Lidsdale Siding Coal Loader – infrastructure upgrades (MP 08_0223 MOD 1)

Thank you for your email dated 4 July 2019 inviting Transport for NSW (TfNSW) review the subject application lodged by Ivanhoe Coal Pty Ltd (Proponent). TfNSW, in consultation with John Holland Rail (JHR), who has been appointed by TfNSW to manage the Country Regional Network (CRN), reviewed the Environmental Assessment (EA) in support of the subject application and provide the following response.

CD19/05650

Attachment A – Detailed comments on MP08_0223 MOD 1

Figure 4 | Lidsdale Siding – proposed modifications

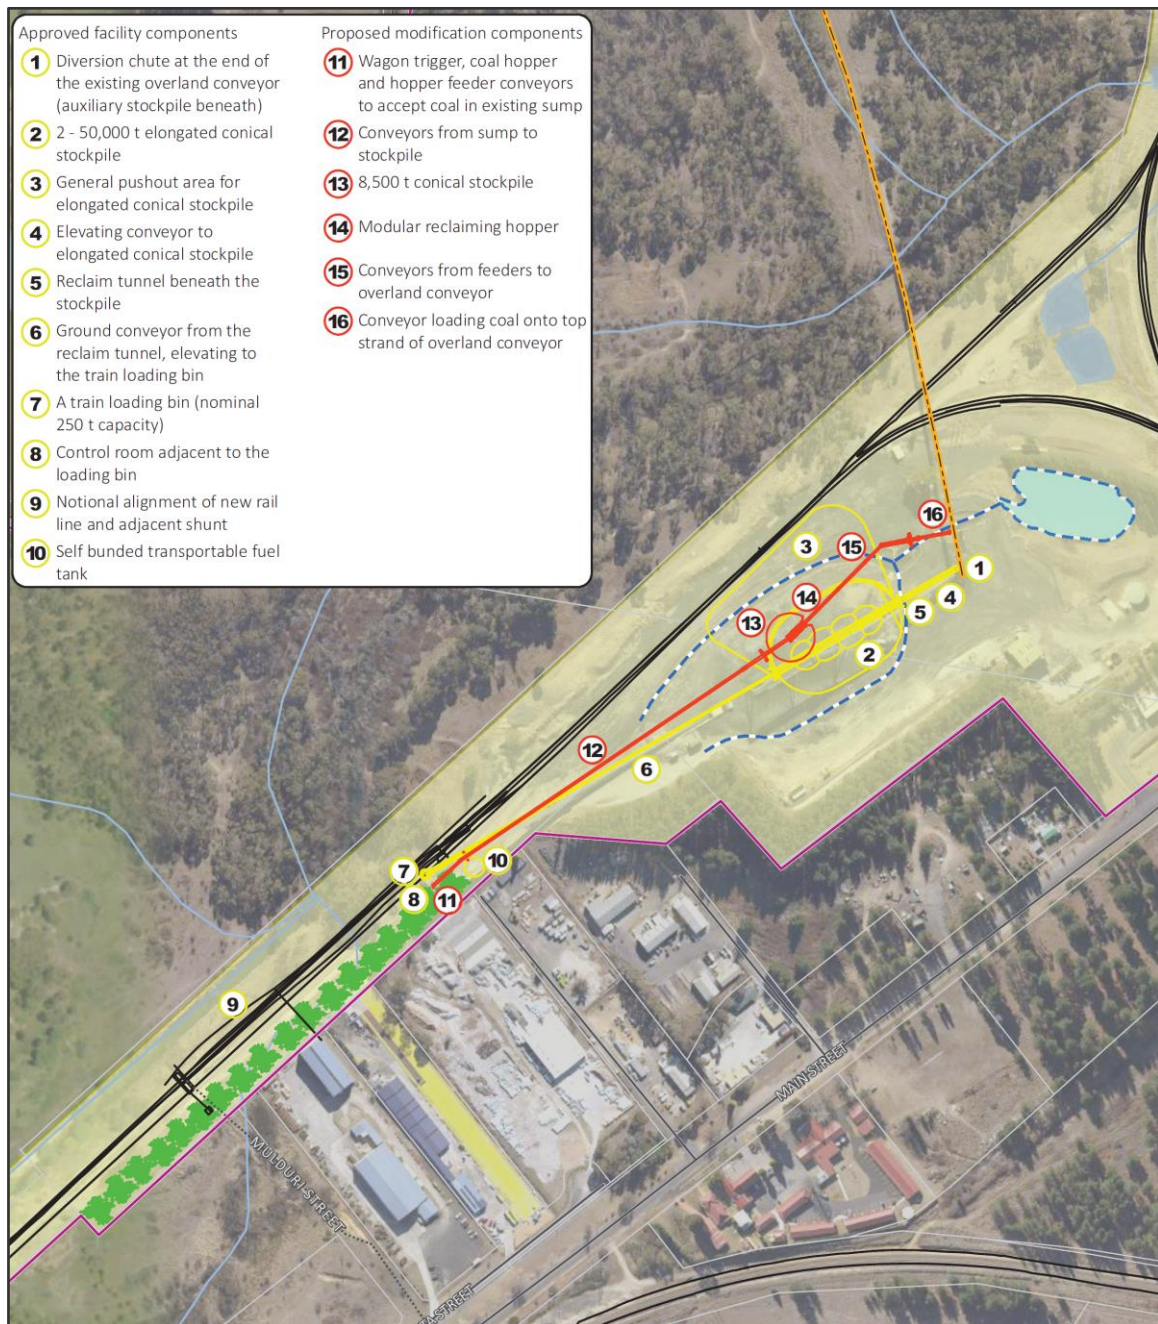
The EA states that the construction activities associated with the proposed changes include the following:

- Minor excavation and levelling associated with footings/pads to support conveyors and stackers;
- Assembly of nominally:
 - Pre-fabricated conveyors including two radial stackers;
 - Two hopper-feeders at the existing under-rail sump at the train loading area; and
 - Three to four tunnel reclaimers with vibrating feeders.

The EA states that minor excavation and levelling associated with footings/pads will be conducted to support construction for conveyors and stackers. However, it does not contain information detailing excavation in respect of the works proposed.

The RtS should include detailed information of excavation in respect of the proposed works.
